Rezoning Transportation Analysis

Petition Number: 2020-197

General Location Identifier: 11707401

Revision Log:

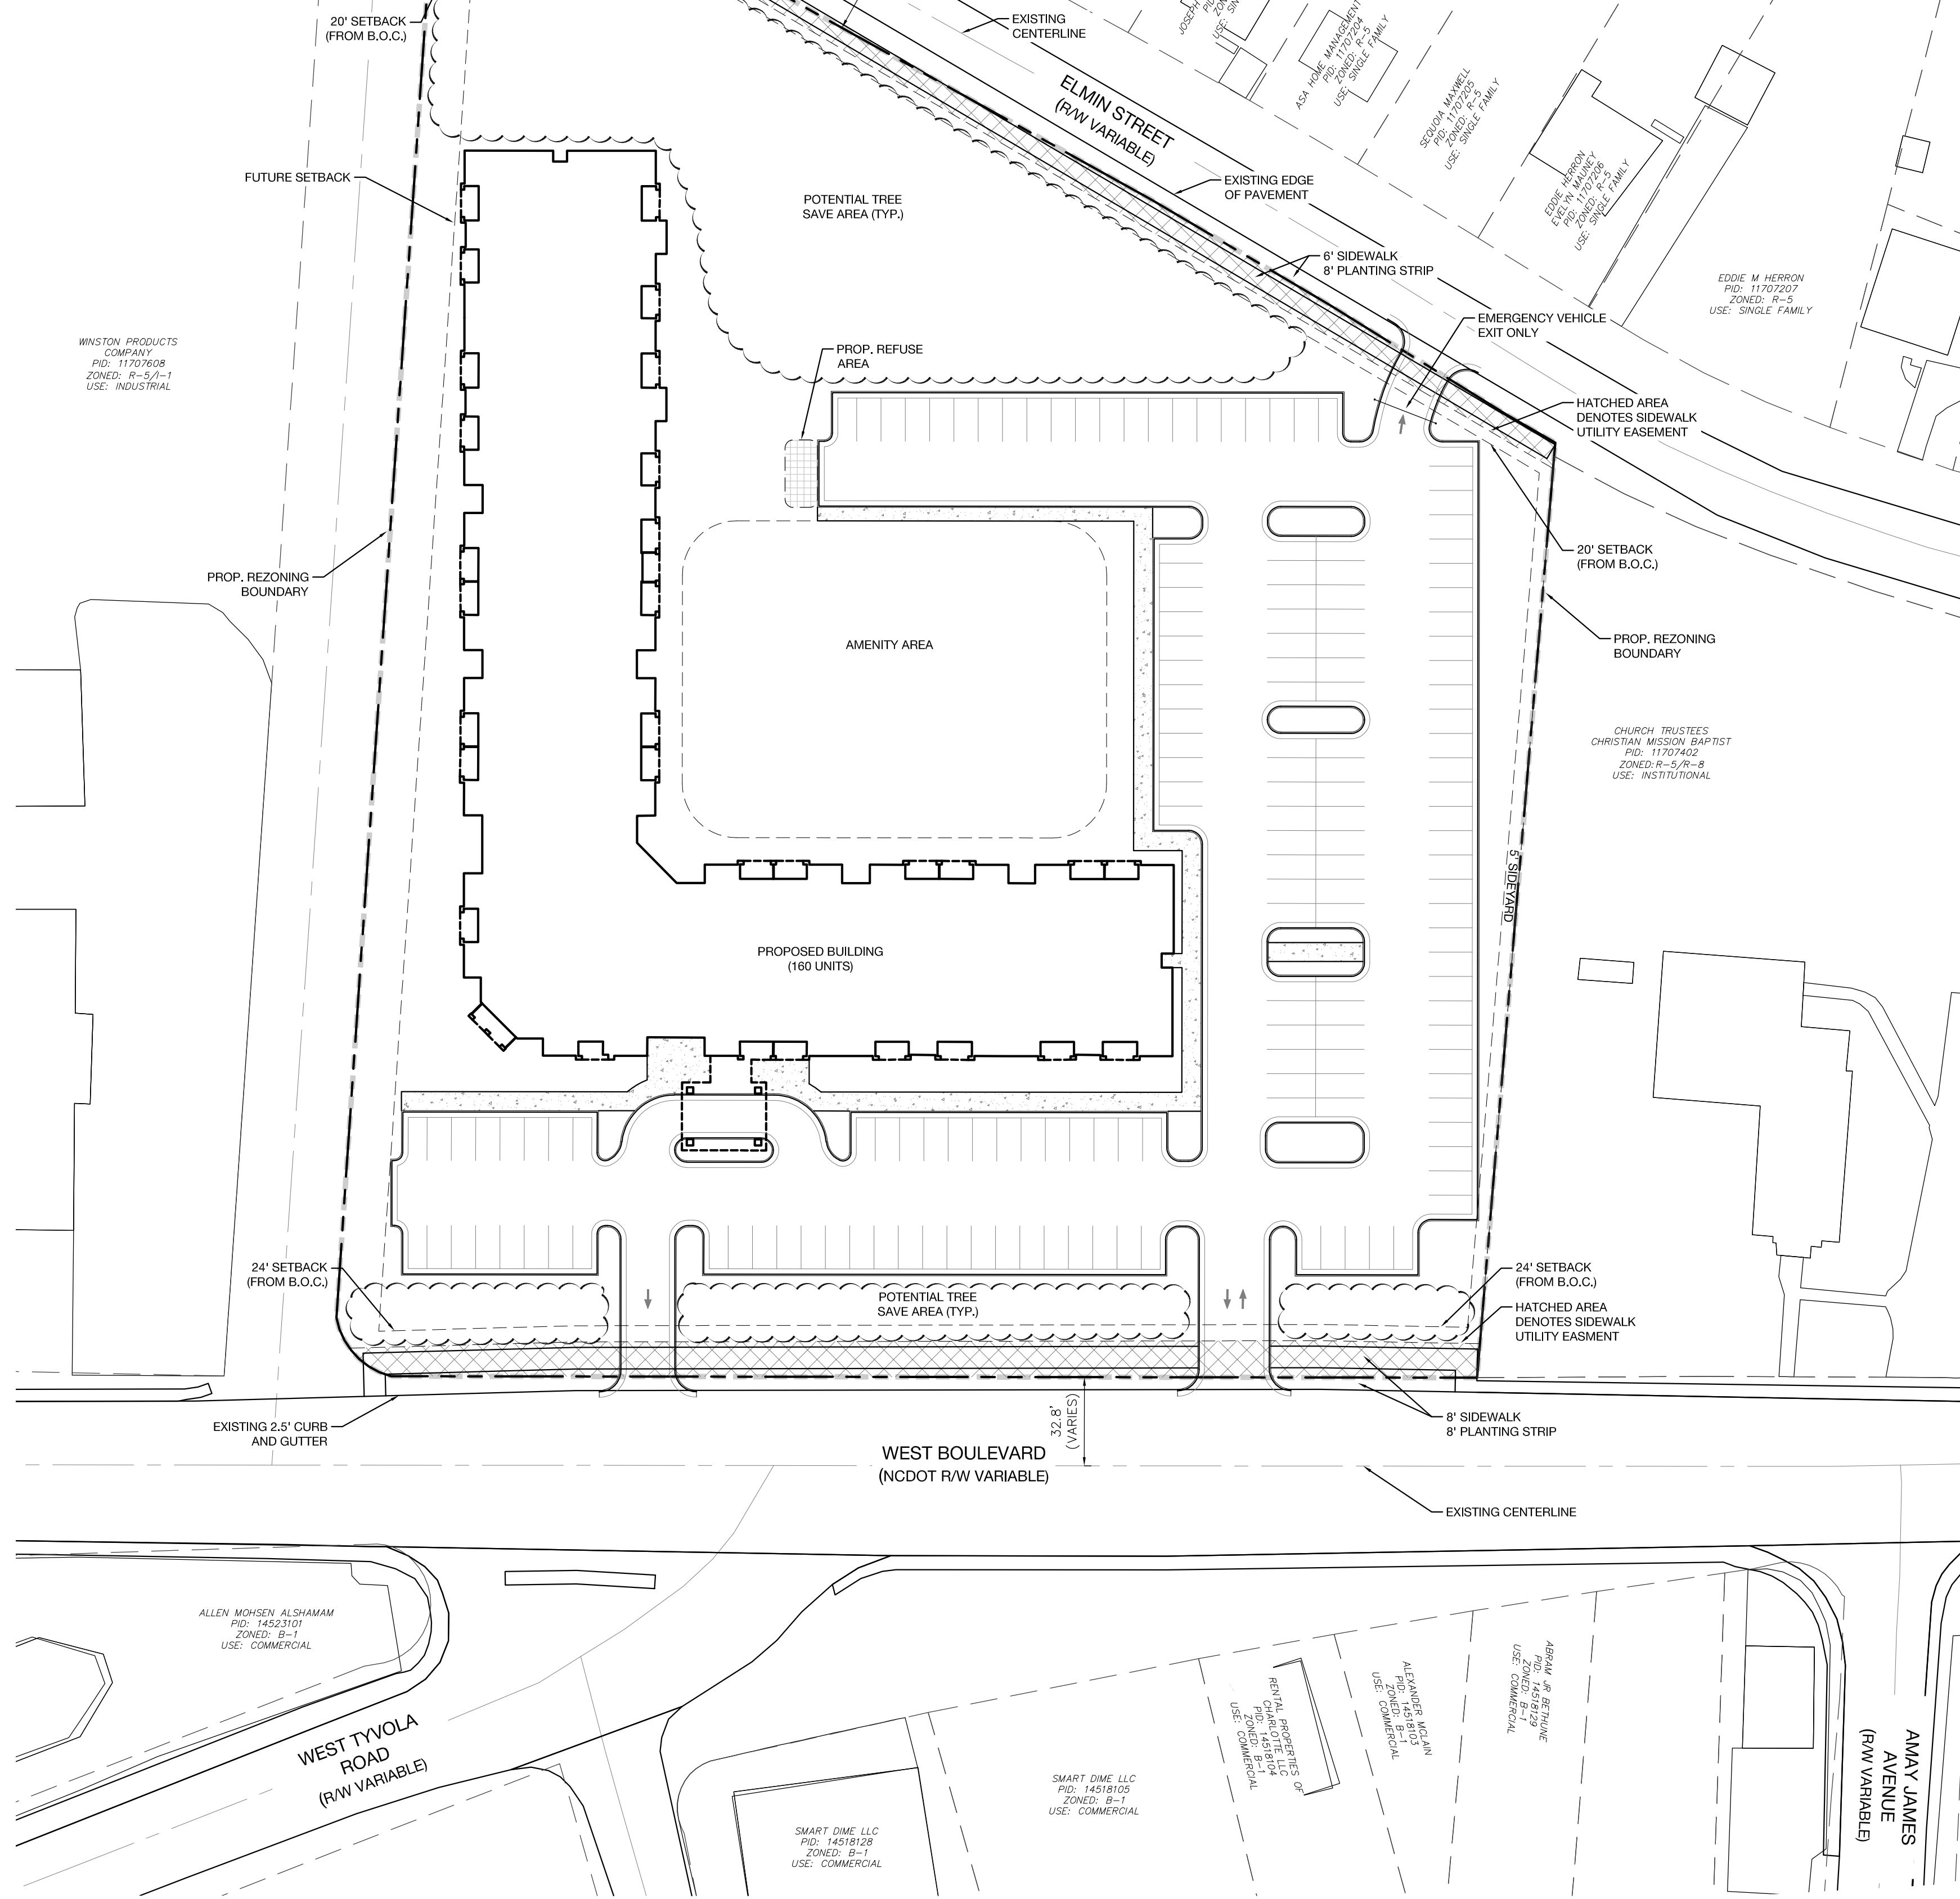
13. A site plan note(s) specifying dedication and fee simple conveyance of all rights-of-way to the City or NCDOT before the site's first building certificate of occupancy is issued is needed. CDOT requests rights-of-way set at 2' behind back of sidewalk where feasible.

14. A site plan note specifying that all transportation improvements will be approved and constructed before the site's first building certificate of occupancy is issued is needed. The petitioner may phase transportation improvements if said improvements and phasing are explicitly described in site plan notes.

18. New comment as a result of the 01-12-2021 Site Plan resubmittal: Revise the site plan to extend the 8-foot sidewalk and planting strip, along Elmin Street, to the west boundary of the paper right-of-way.

19. New comment as a result of the 01-12-2021 Site Plan resubmittal: Remove conditional note 3.E. No portion of this right-of-way will be abandoned.
